Our Ref: 191183
Planning Ref: A/104/19/RES

11 September 2019

CRETE NURSERY, DAPPERS LANE, ANGMERING, BN16 4EN

191183/510/01

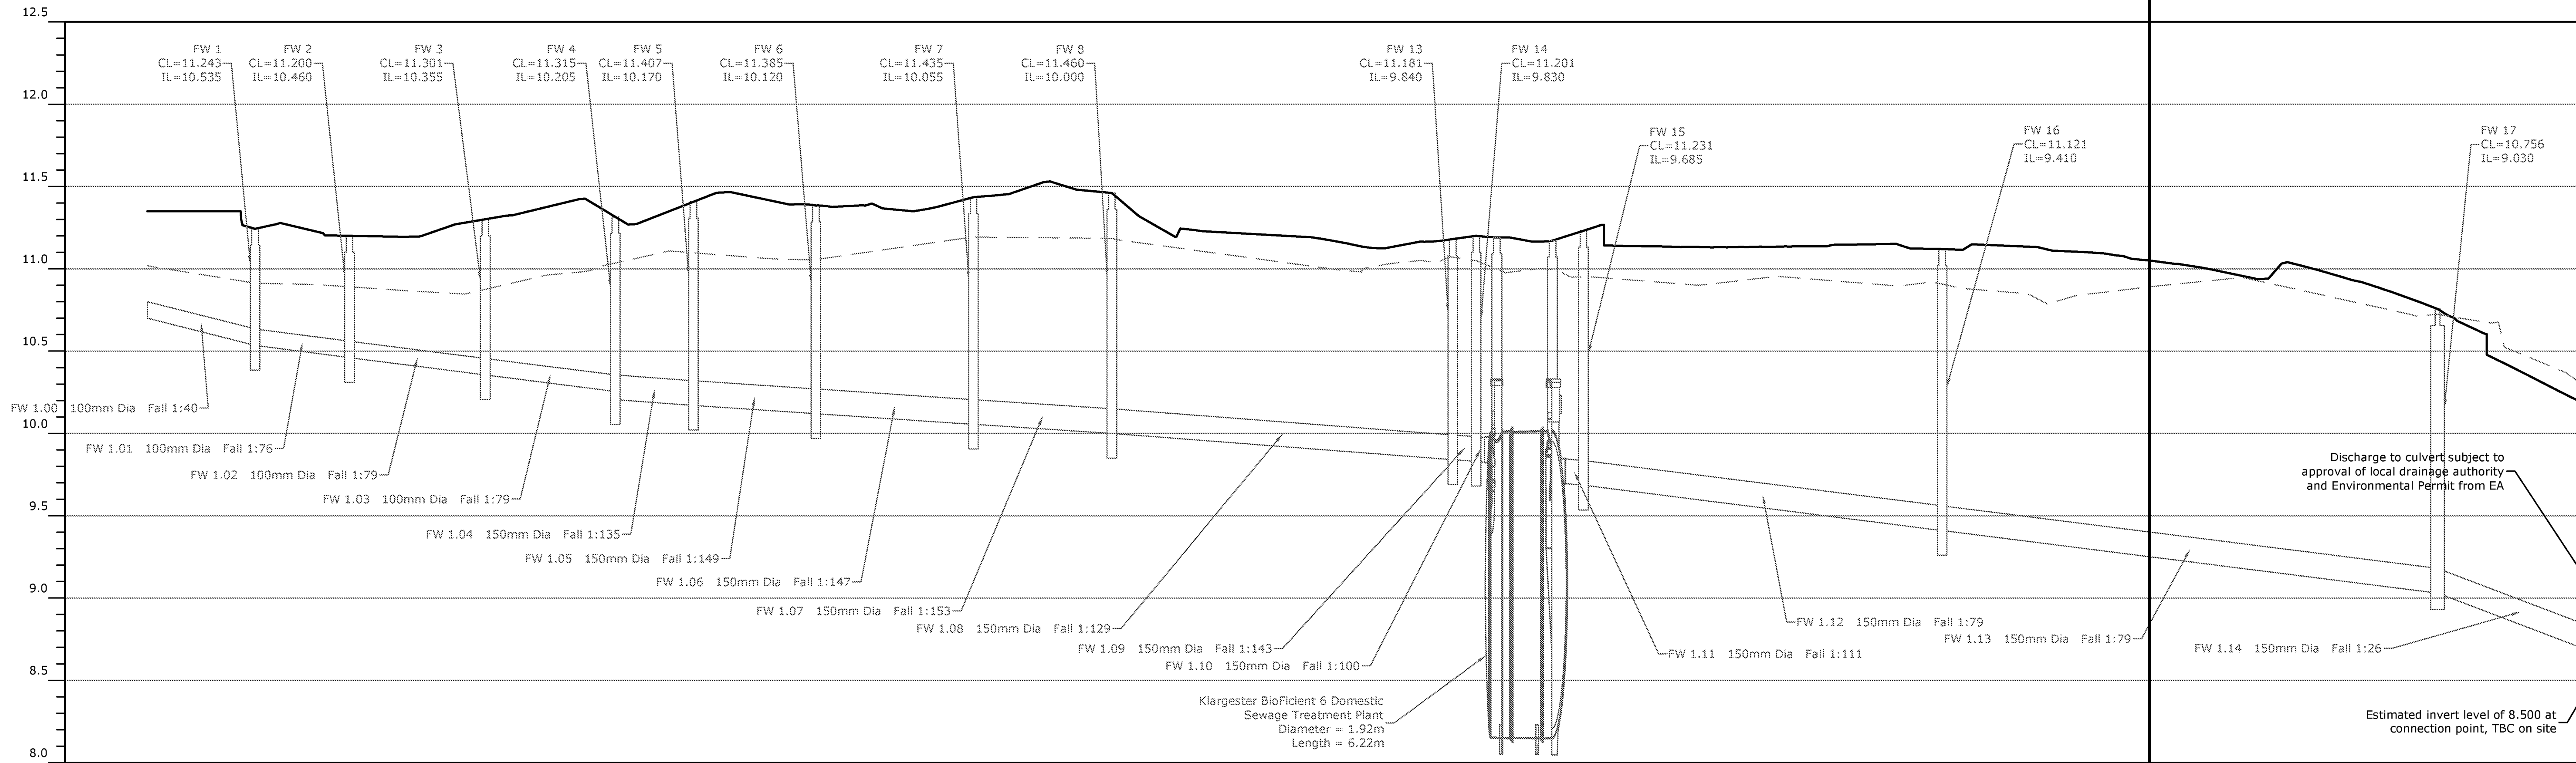
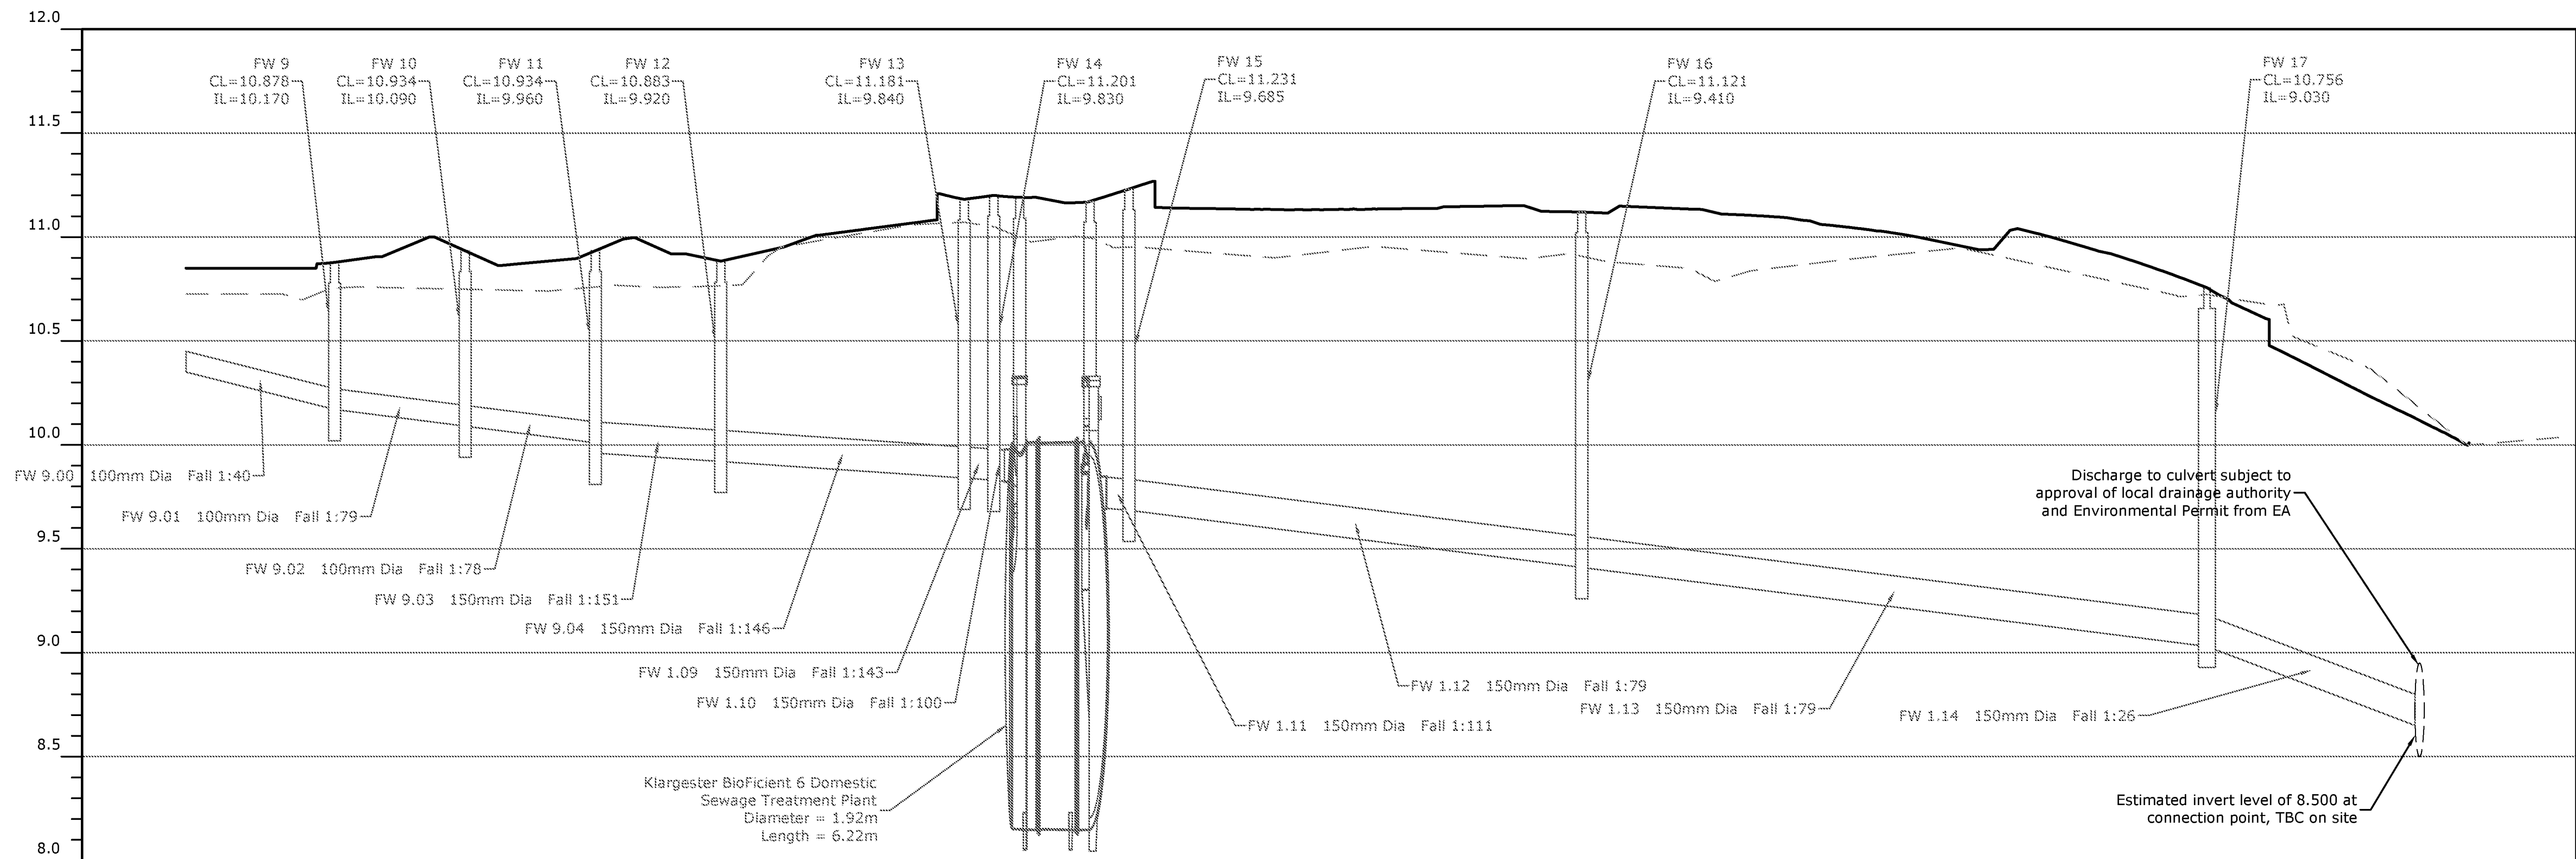
- 1 & 2 We enclose additional documents from Constructive Evaluation as part of their investigation. This provides full details of the groundwater monitoring. The highest and lowest groundwater levels at each location are as follows;
WS1 max = 1.48m bgl min = 1.69m bgl
WS2 max = 0.83m bgl min = 1.13m bgl
WS3 max = 0.43m bgl min = 1.04m bgl
The infiltration test was close to WS3 where the groundwater level is lower. The testing was in accordance with BRE365 and the location and depth close to the proposed filter drain.
- 3 Please refer to enclosed drawing 191183/SK/04 for impermeable areas.
- 4 & 5 The groundwater monitoring found that the highest groundwater level in the vicinity of the filter drain was 1.48m below ground level. This has been shown on the filter drain long section

drawing 191183/520/02 and therefore the filter drain will be above the maximum groundwater level. As shown on the drawing, Filter Drain 1 is flat, and Filter Drain 2 is sloped, and this is correctly reflected in the MicroDrainage calculations.
